DATE: September 9, 2022

SUBJECT: Ellicott Gas Station
RE: Traffic Impact Study
Response to CDOT Comments Memorandum
LSC #204481

Following are the LSC Transportation Consultants, Inc. responses to the January 12, 2022 CDOT Comments (posted to EDARP) regarding CS-21-002.

## Site Plan

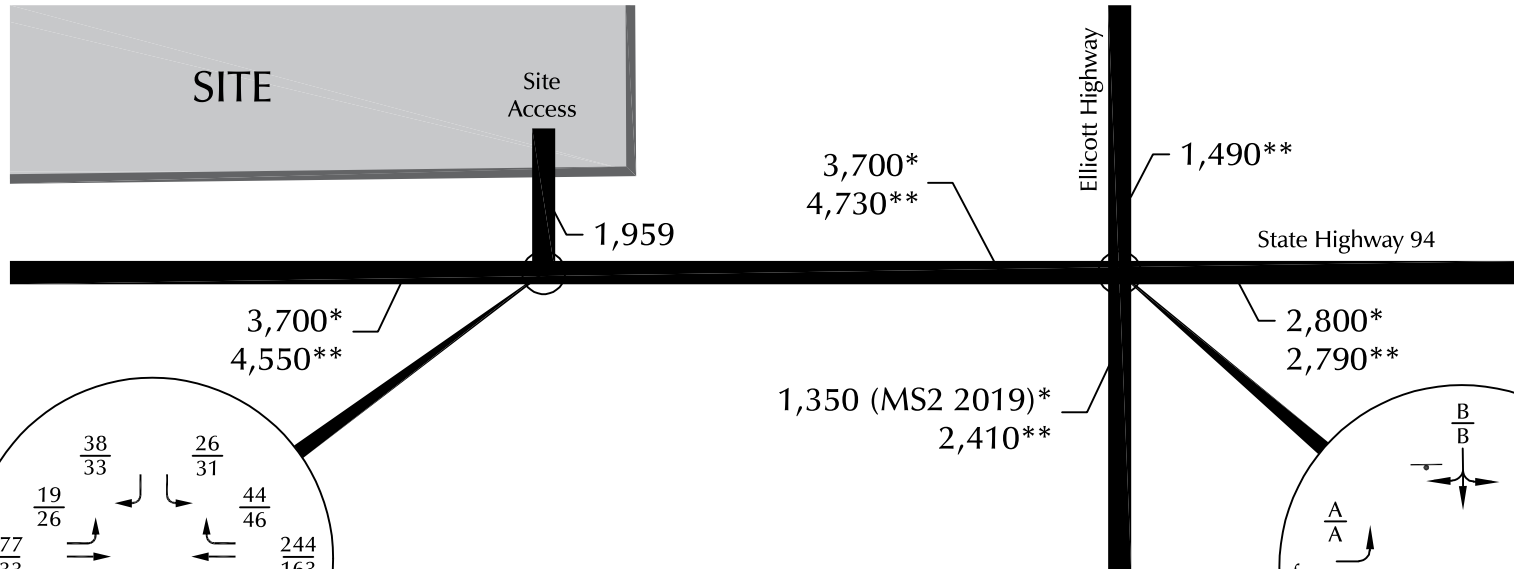
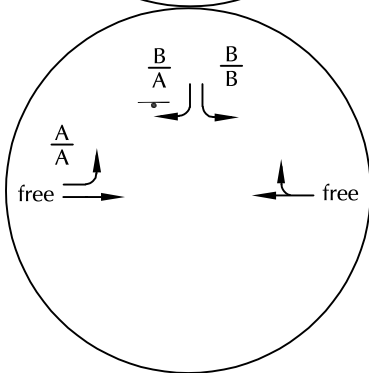
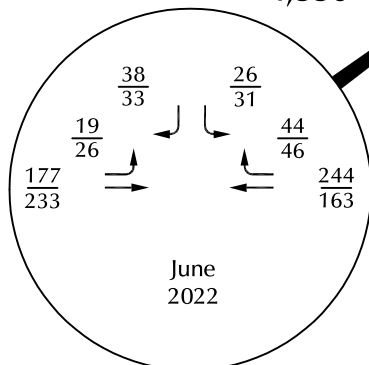
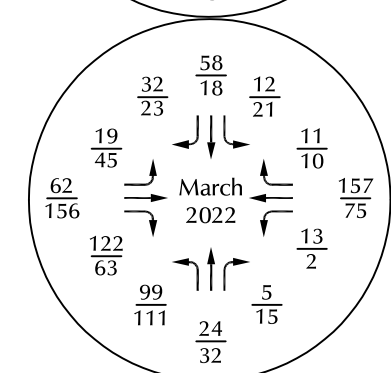
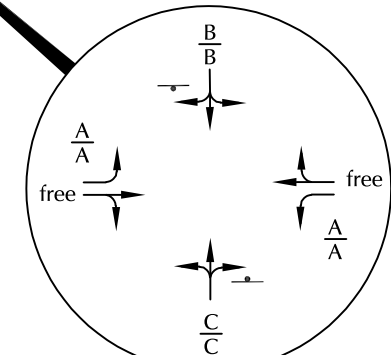
9. *The site plan provided shows a total of 4 proposed accesses: a one-way ingress next to a full movement driveway on the west side of the parcel and a one-way egress next to a full movement driveway near the east side of the parcel. Only one single point of access is allowed by the SHAC access should be allowed and only if it can meet the standards of the SHAC.*

- 13. A revised site plan with access that meets the standards of the SHAC needs to be provided.*

LSC Response: The site plan and proposed access plan has been revised. Please refer to the "Access Plan" section of the TIS and Figure 2, which depicts a proposed access reconfiguration plan.

LSC Response: The site plan and proposed access plan has been revised. Please refer to the “Access Plan” section of the TIS and Figure 2, which depicts a proposed access reconfiguration plan.
